From: [Dale Rodmell](#)
To: [Norfolk Vanguard](#)
Cc: [REDACTED]
Subject: Norfolk Vanguard - Written Representation on behalf of NFFO and VisNed
Date: 15 January 2019 18:26:03
Attachments: [190115 NFFO VisNed Written Representation - Final.pdf](#)

Our ref: NFFO/3727/DR
Your ref: EN010079

Application by Norfolk Vanguard Limited for an Order Granting Development Consent for the Norfolk Vanguard Offshore Wind Farm Project: Written Representation

Drawing file: published-documents / EN010079-001752-Figure 14.05 Dutch Beam Trawls VMS Effort 2012-2016.pdf

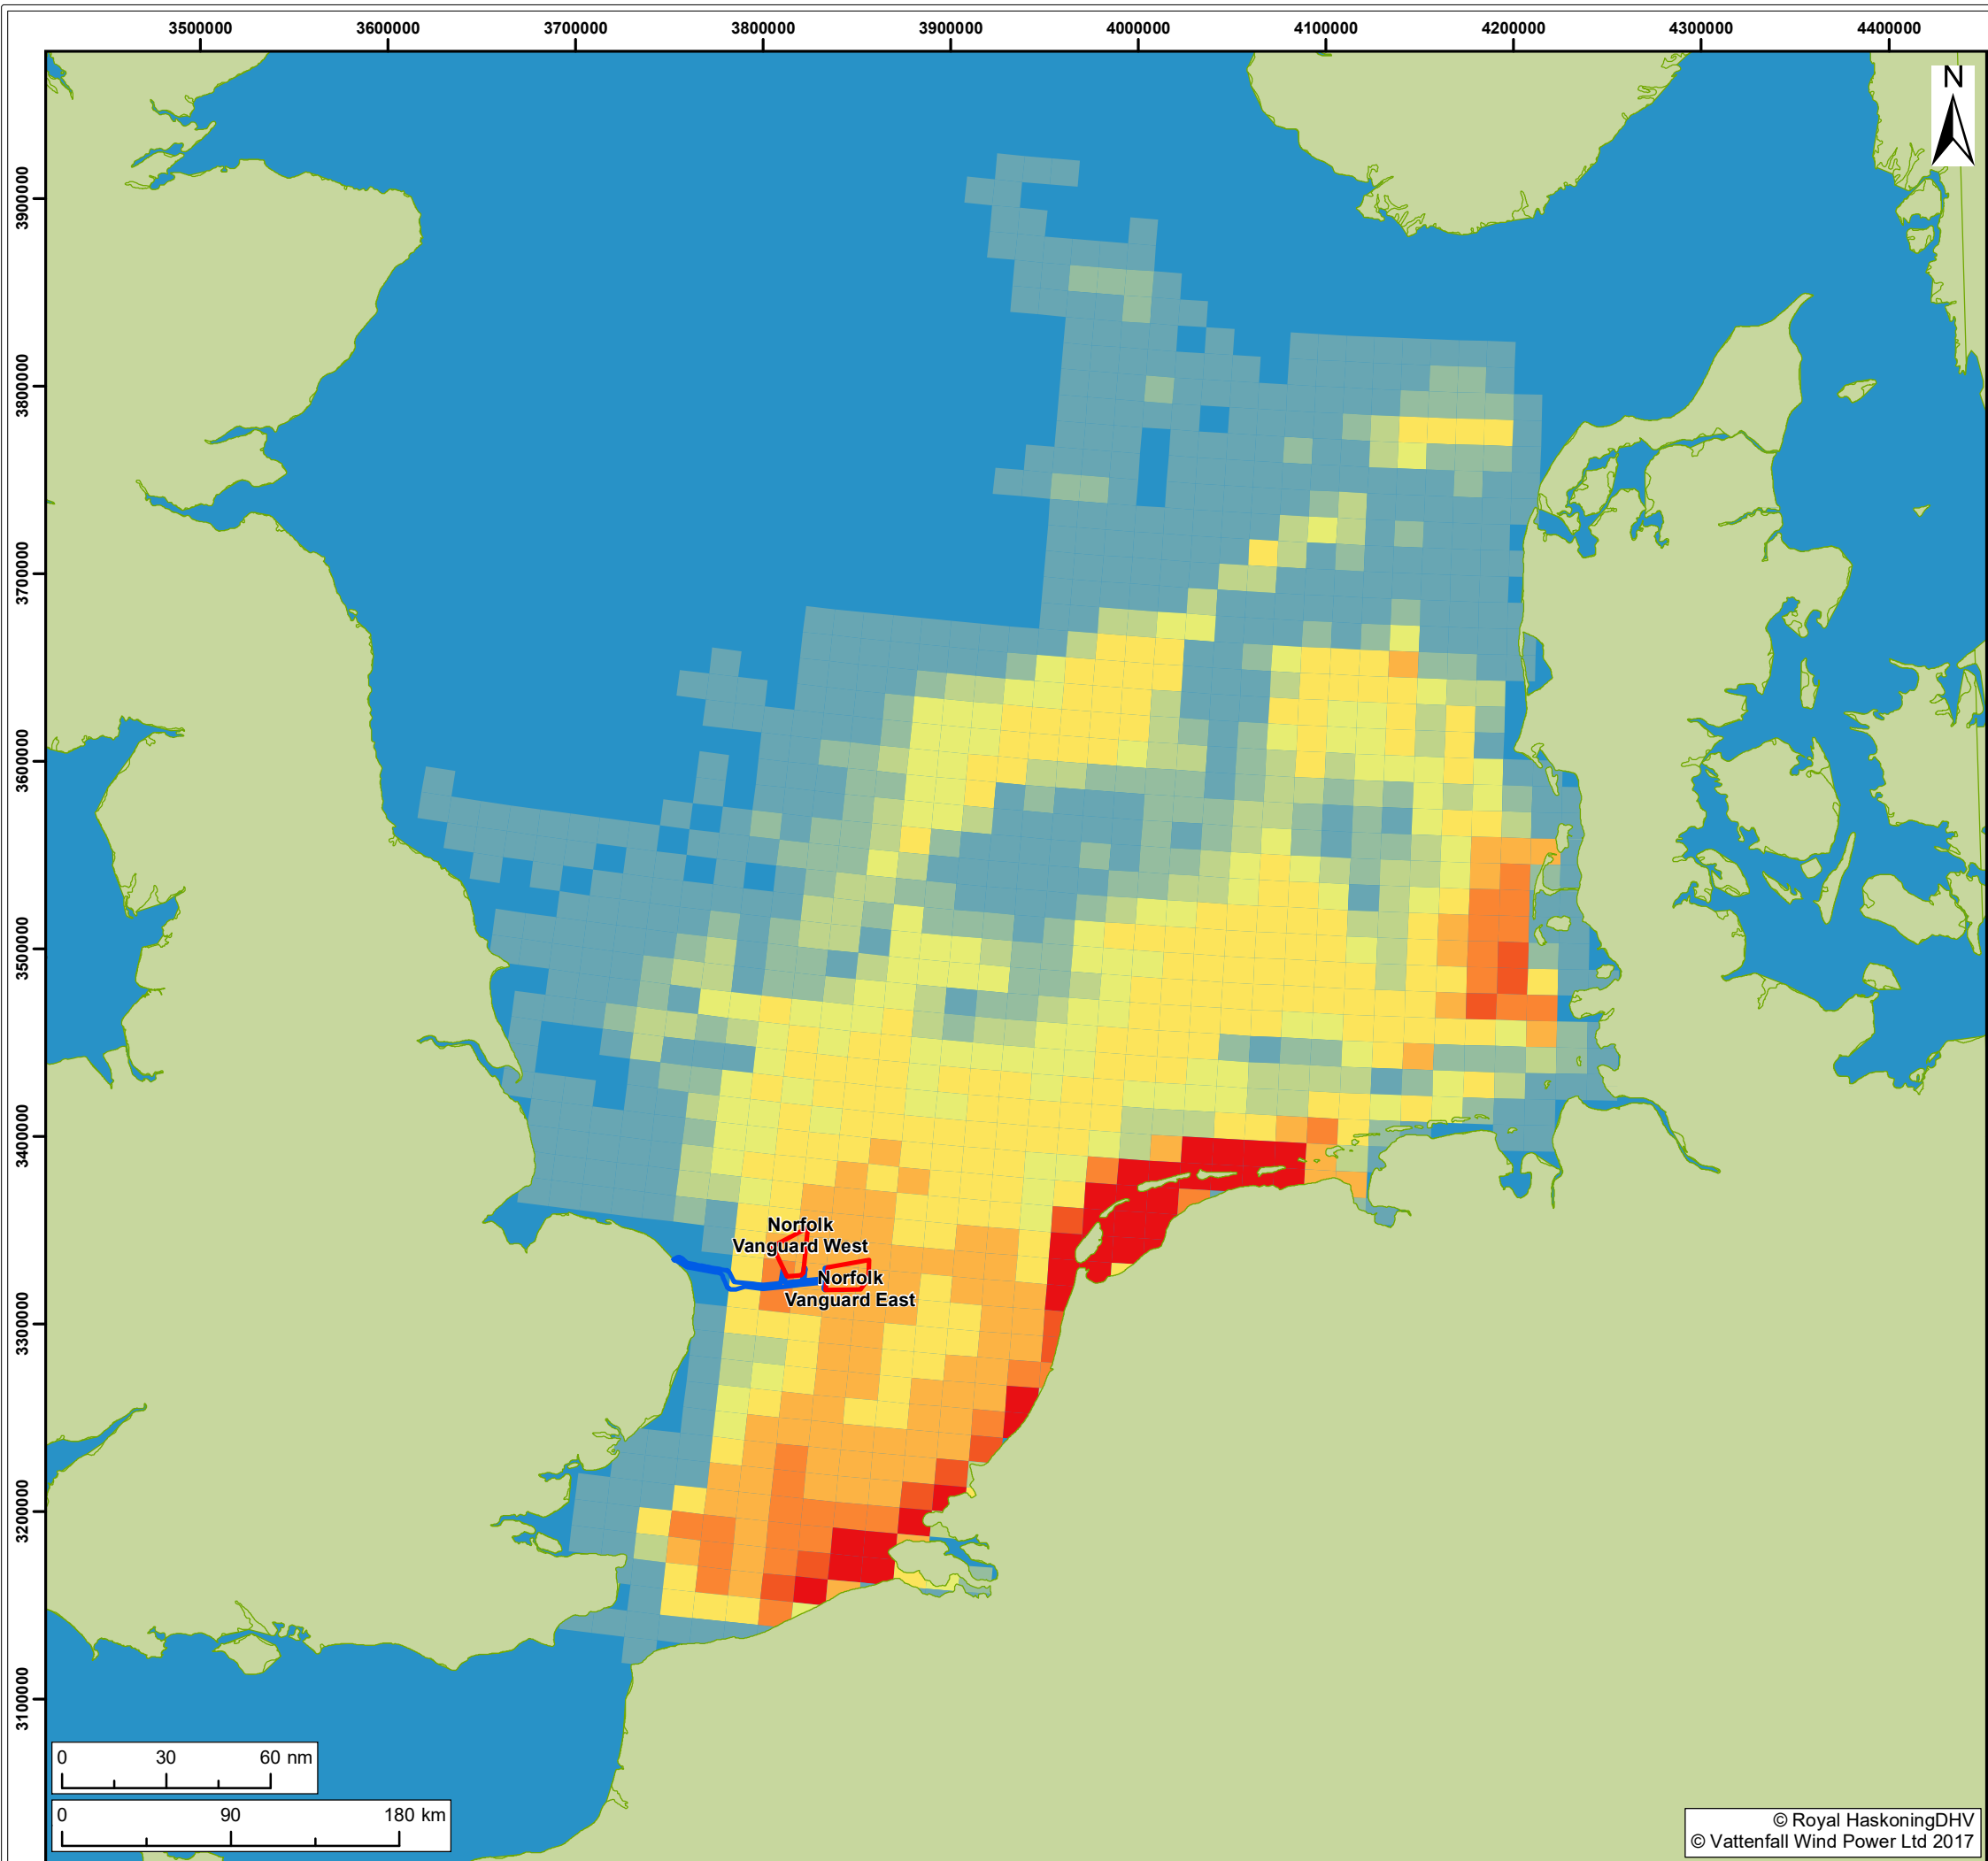
Other projects proposed in the East Anglia Zone represent a significant overlay with one of the most heavily fished areas for the Dutch beam trawl fleet. The Norfolk Boreas project also proposes to include floating wind within its design envelope which we anticipate would exclude all types of fishing activity from the area of the array.

On this basis, and without further evidence, **we do not agree with the conclusion that the significance of impact due to loss or restricted access applying to the project operational phase is minor-adverse for the Dutch beam trawl and seine net fisheries, UK beam trawl, and minor local inshore vessels.** Indeed, the equivalent CEA recently completed for the Hornsea 3 offshore wind farm project classifies impact significance as moderate adverse for demersal trawlers (including fly shoot seines) which is significant in EIA terms¹.
